Project Memo

DATE: September 23, 2025
TO: Community Design Solutions, LLC & J&M Discount Towing LLC
FROM: Dustin Kiska, Planner (505)-924-3366 & Daniel Soriano, Planner (505) 924-3935
City of Albuquerque Planning Department
RE: Project # SP-2025-00066 Site Plan – EPC

LANDSCAPING PLAN

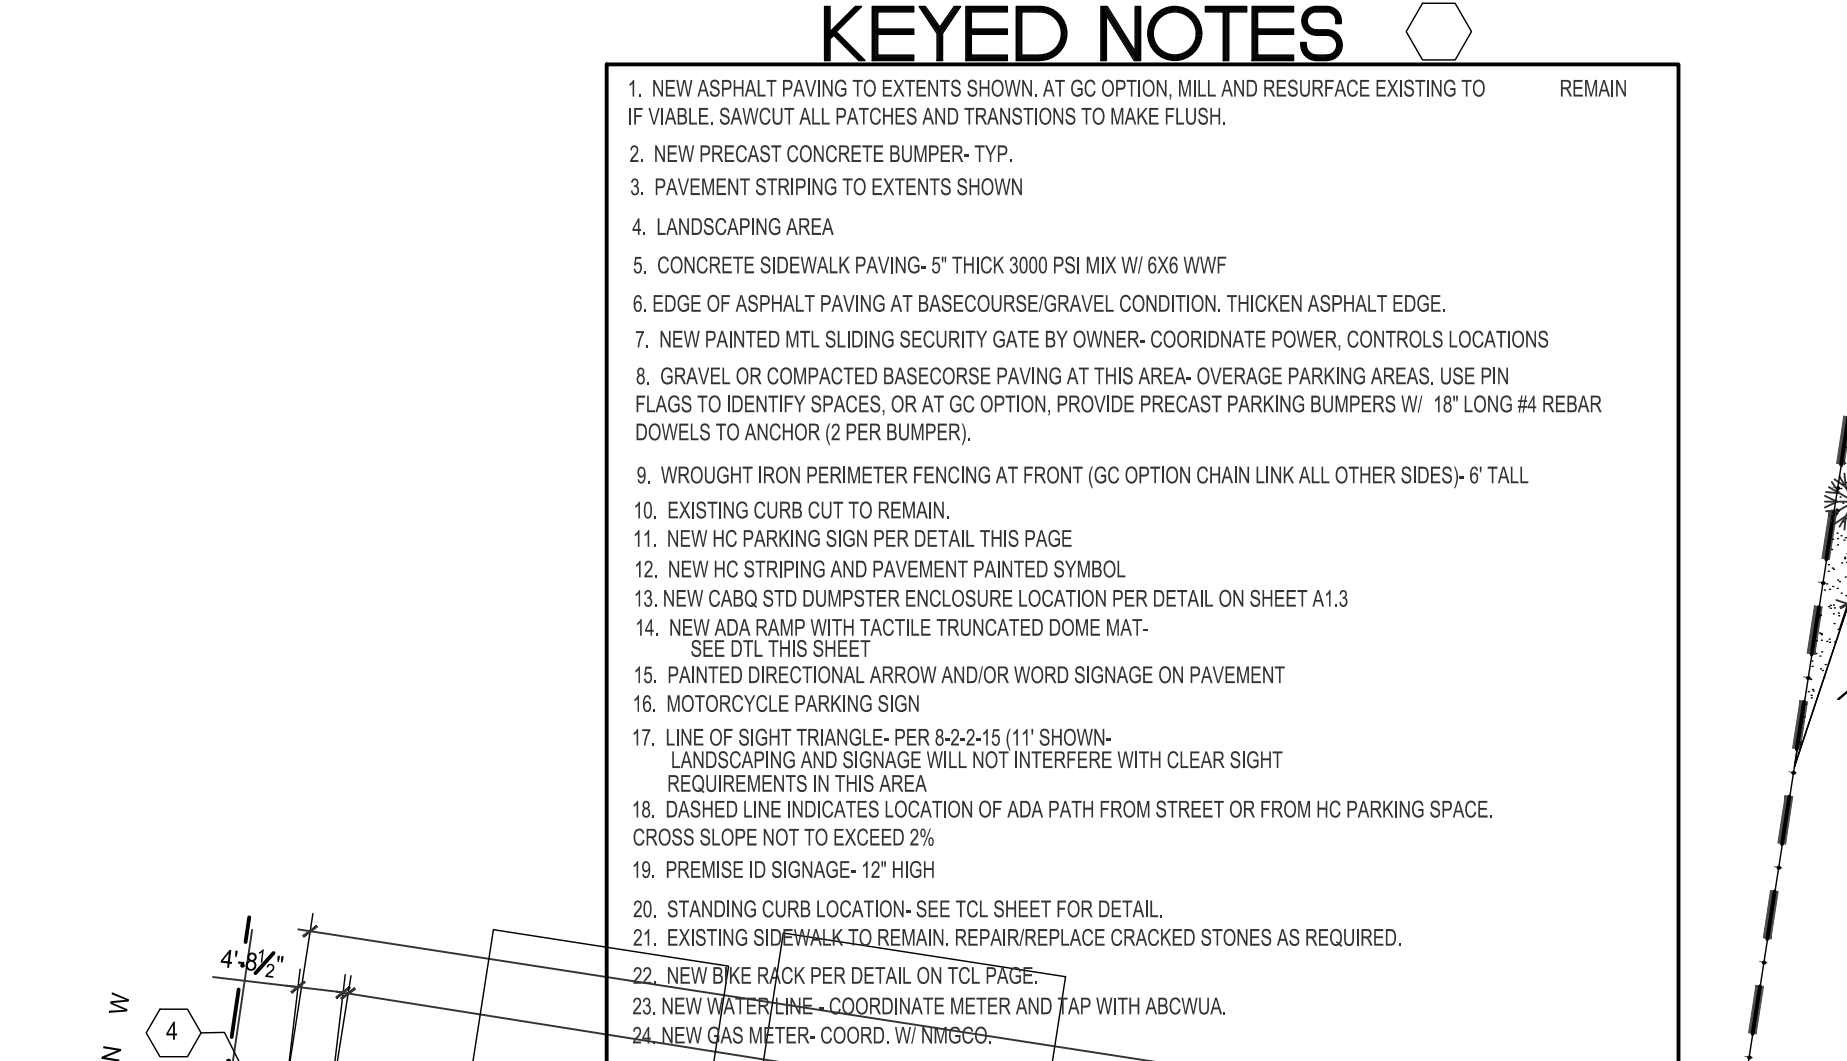
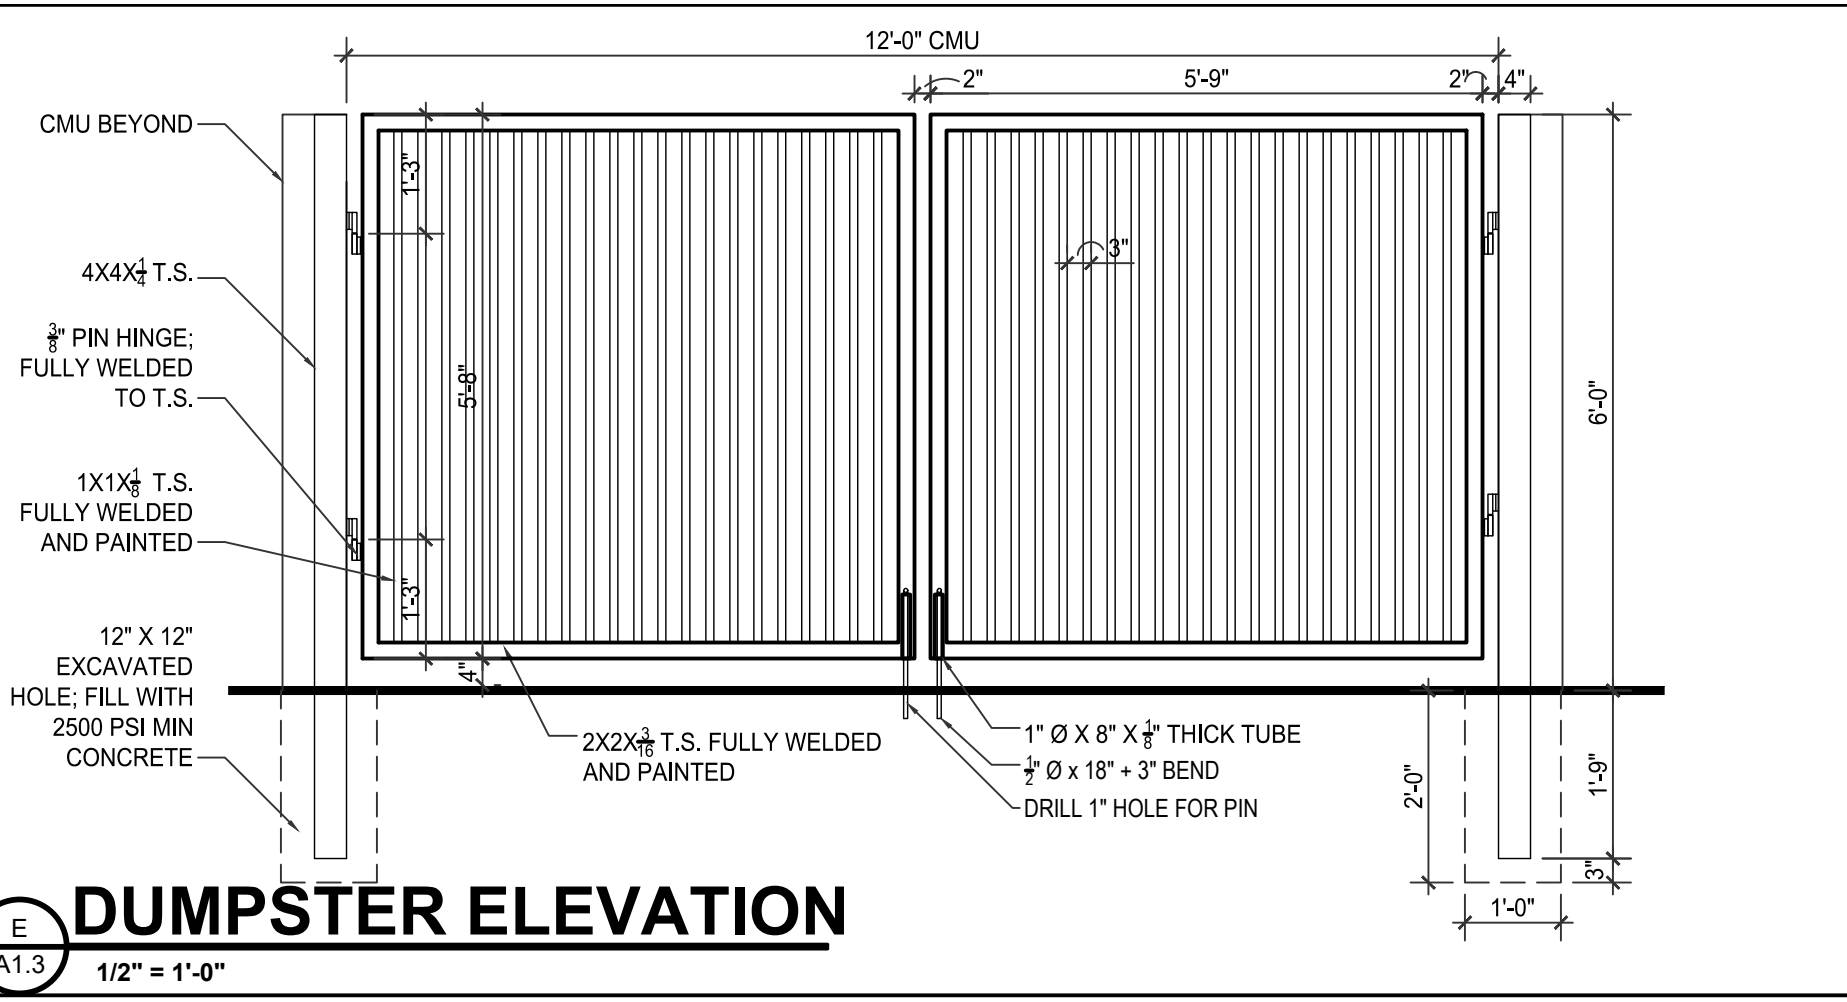
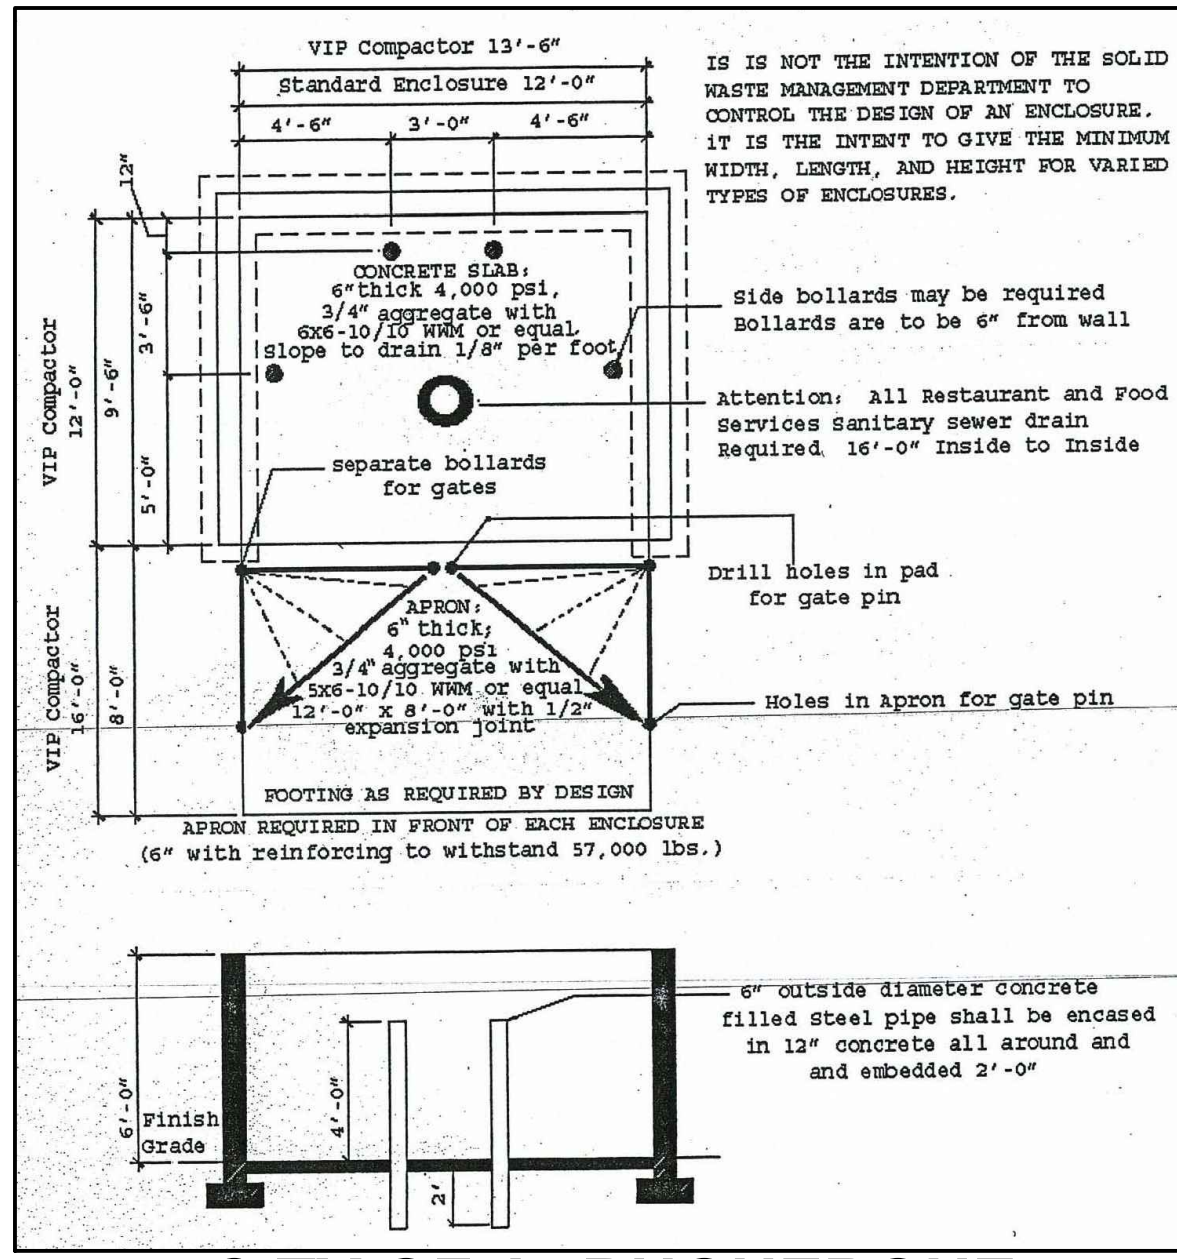
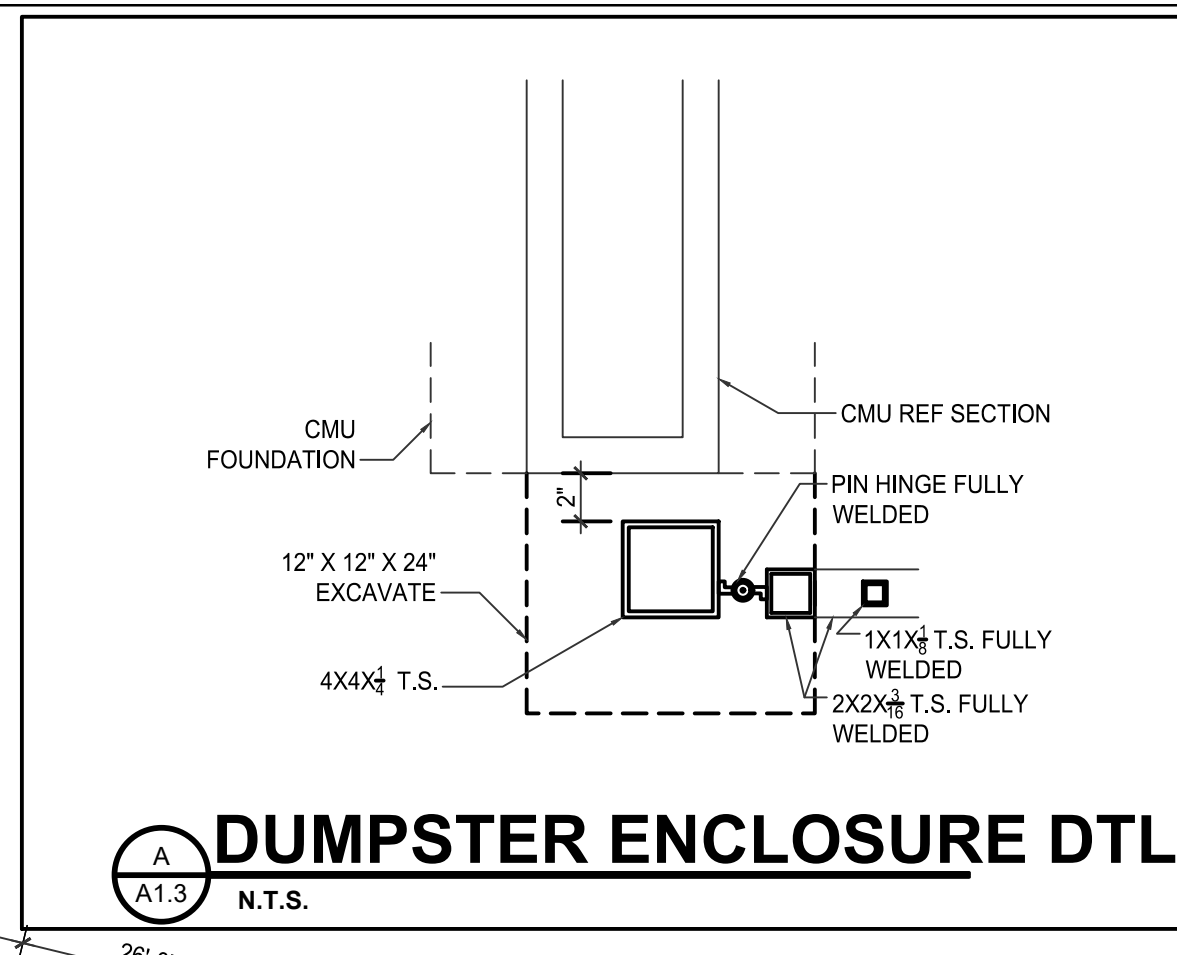
- Required Landscape buffer: It is stated 15% Landscape area is required, requirement is met.
- Please provide # quantity of plant units proposed to be installed. This can include additional information like gallons of water required per plant, Latin name, etc. but not as important.
- It looks like the plant types chosen, satisfy the City Plant Pallet. Thank You
- Are there any existing trees that will be removed in order to fulfill this design? Please note location and add keyed note if so.
- Street Trees are to be placed 25' o.c. not 30' apart o.c. per 5-6(D)(1)
- A landscaped edge buffer area at least 6 feet wide shall be provided.

- Please include an irrigation plan for the proposed landscaping per 5-6(C)(14)

SOLID WASTE SITE PLAN
1 A1.3

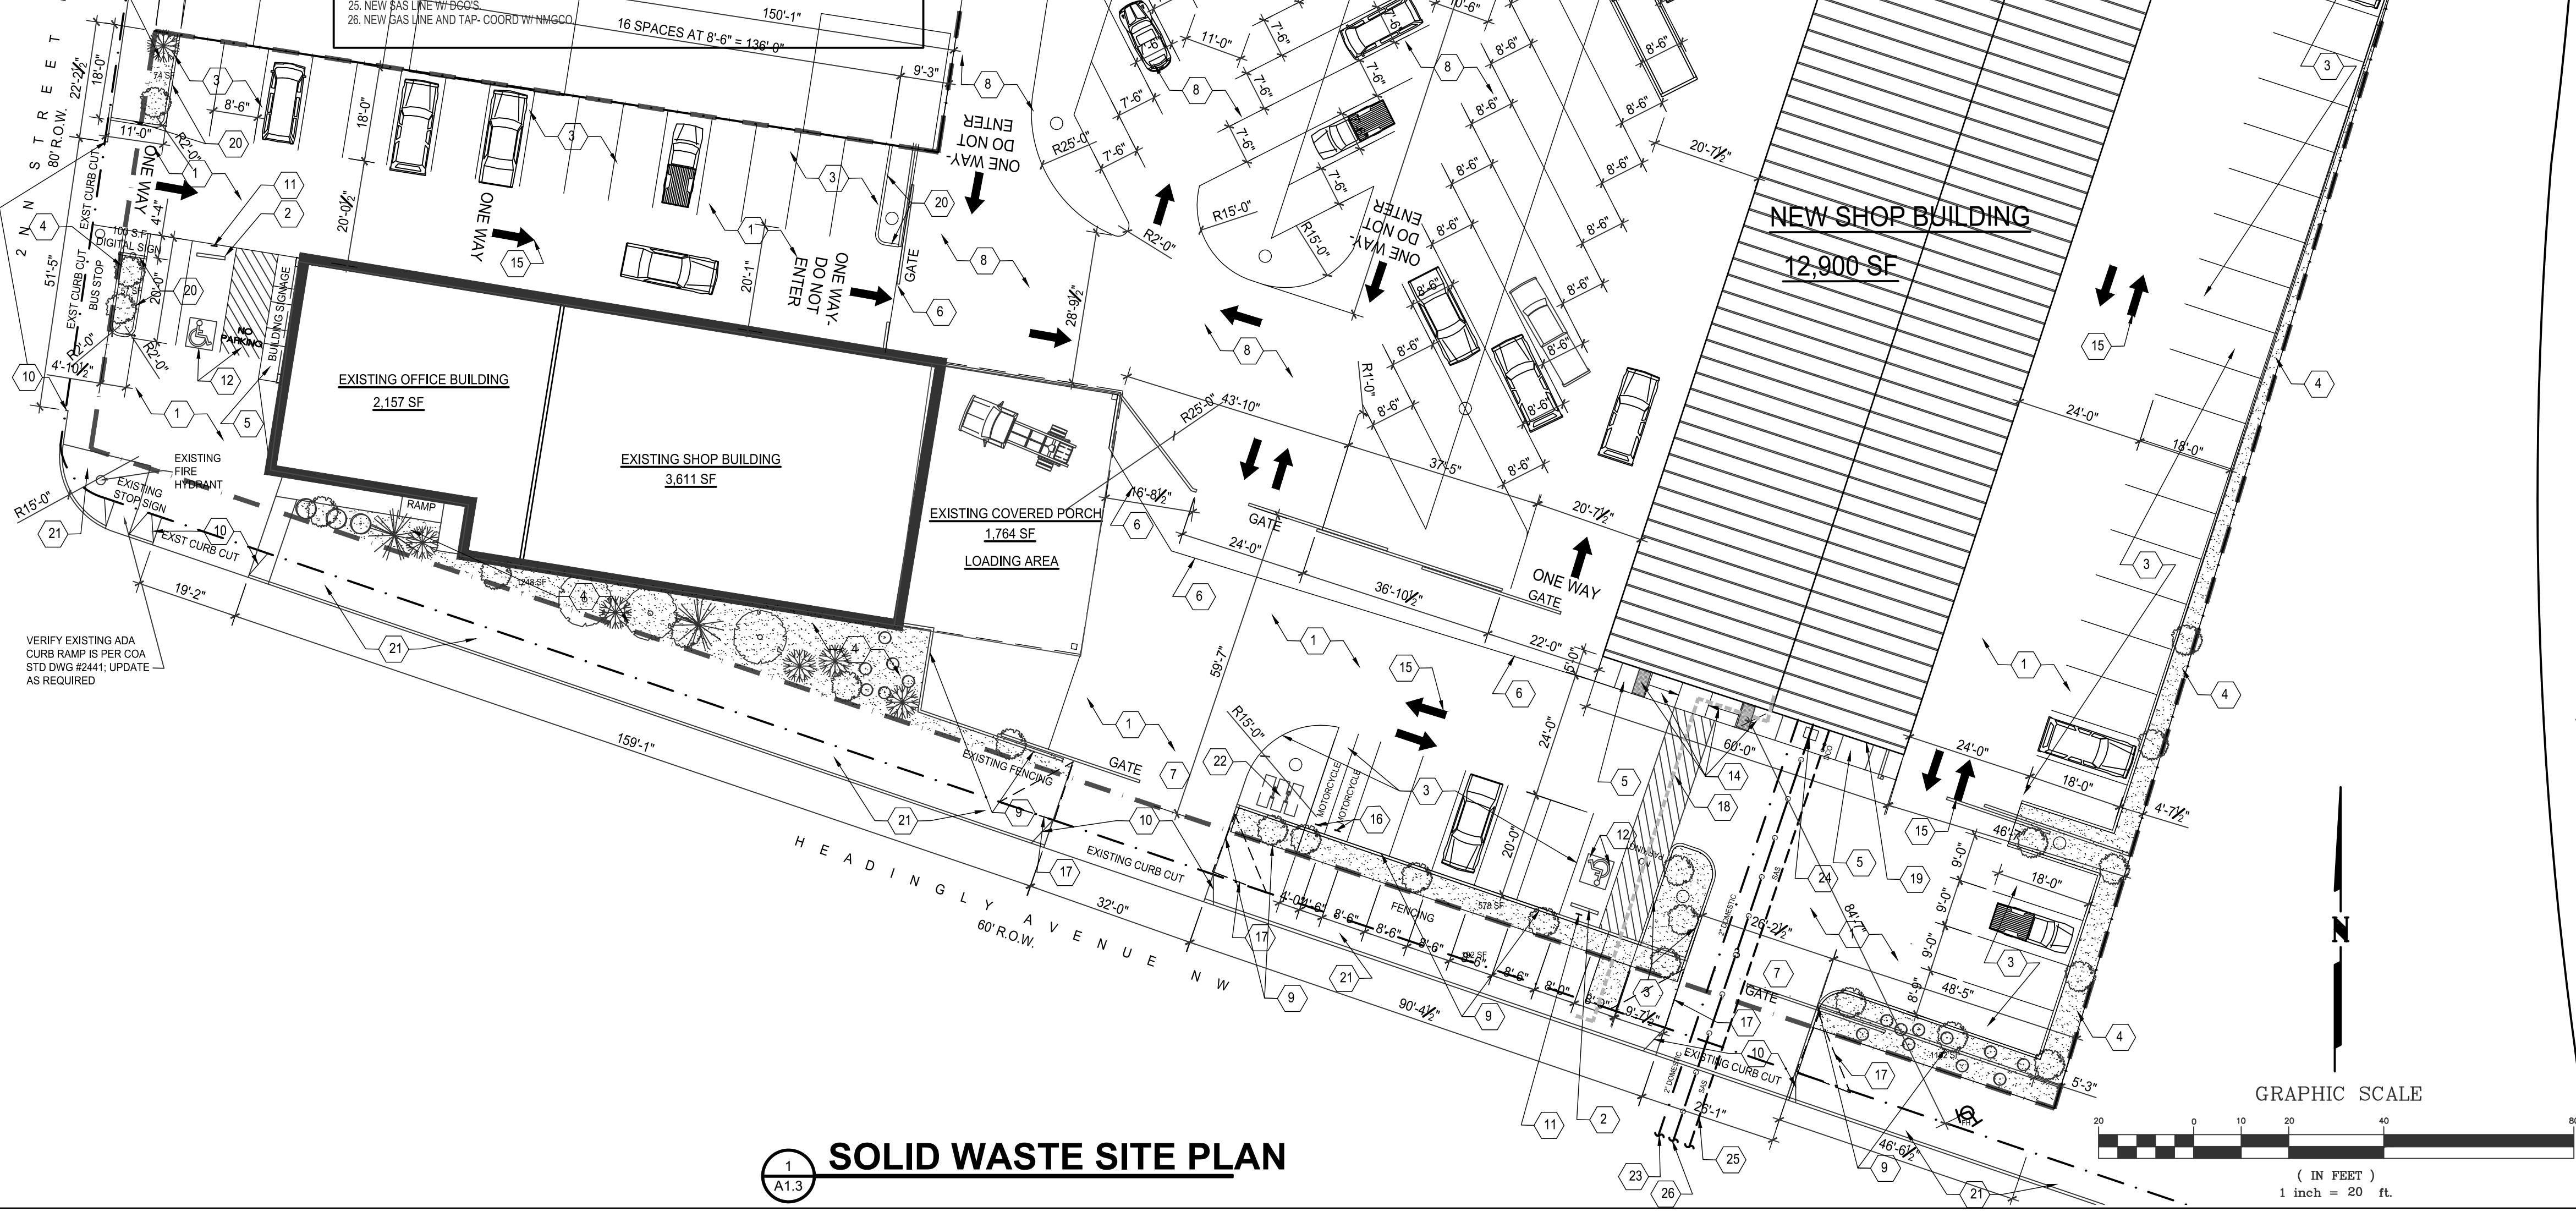
- Please provide a vicinity map on the first sheet, similar to the one seen on the Grading and Drainage plan sheet. Zone Atlas page is ok to include but will not function well as a vicinity map. Please revise it to show the context around the immediate vicinity of the subject site.
- Please provide a calculation for possible on-street parking along Headingly Ave.
- Keyed notes on the solid waste plan are hard to read.

1 SITE UTILITIES
 A1.3

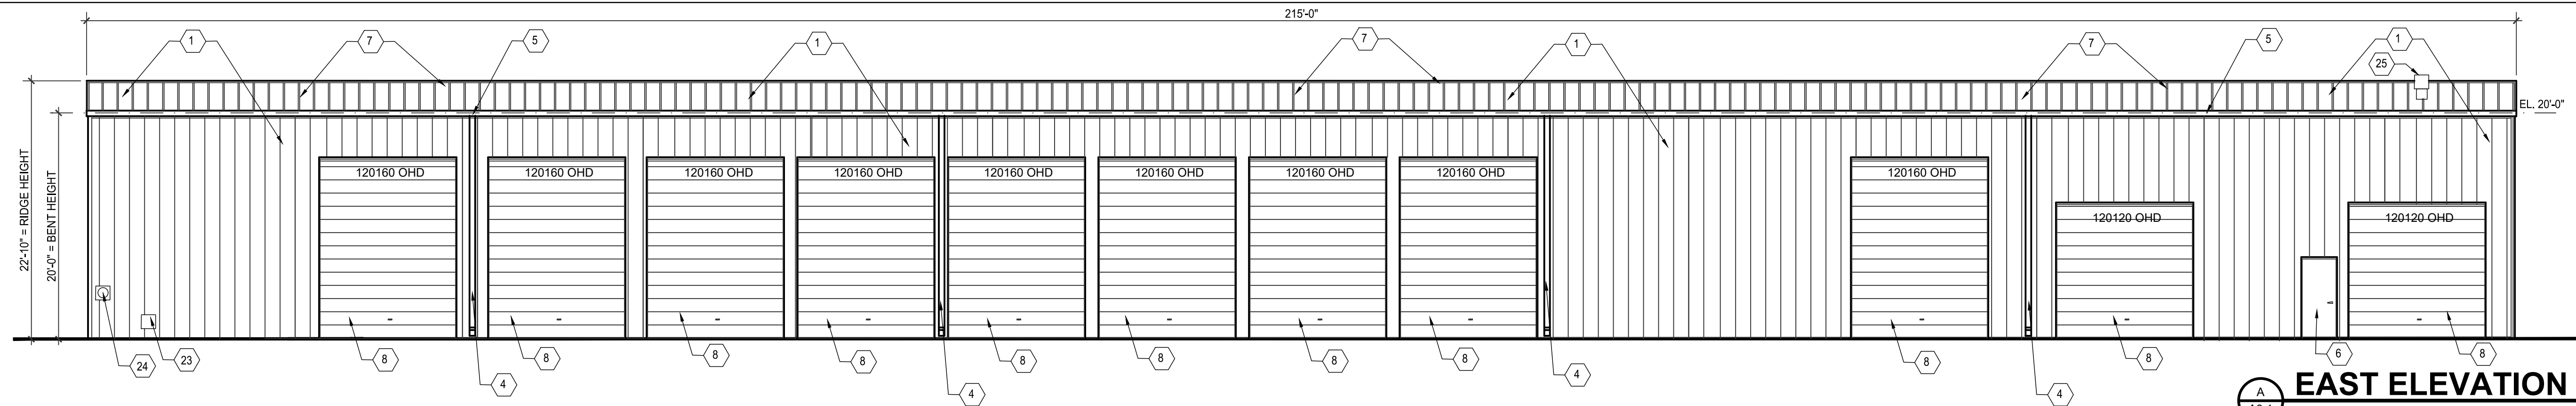
- Please tag the powerline easement dashed line running along 2nd street. Is there a powerline easement to the east? It can't hurt to show it if it is in close vicinity of the property line, so it is understood that it is not affected by the project. Move the graphic scale to a better location if needed.
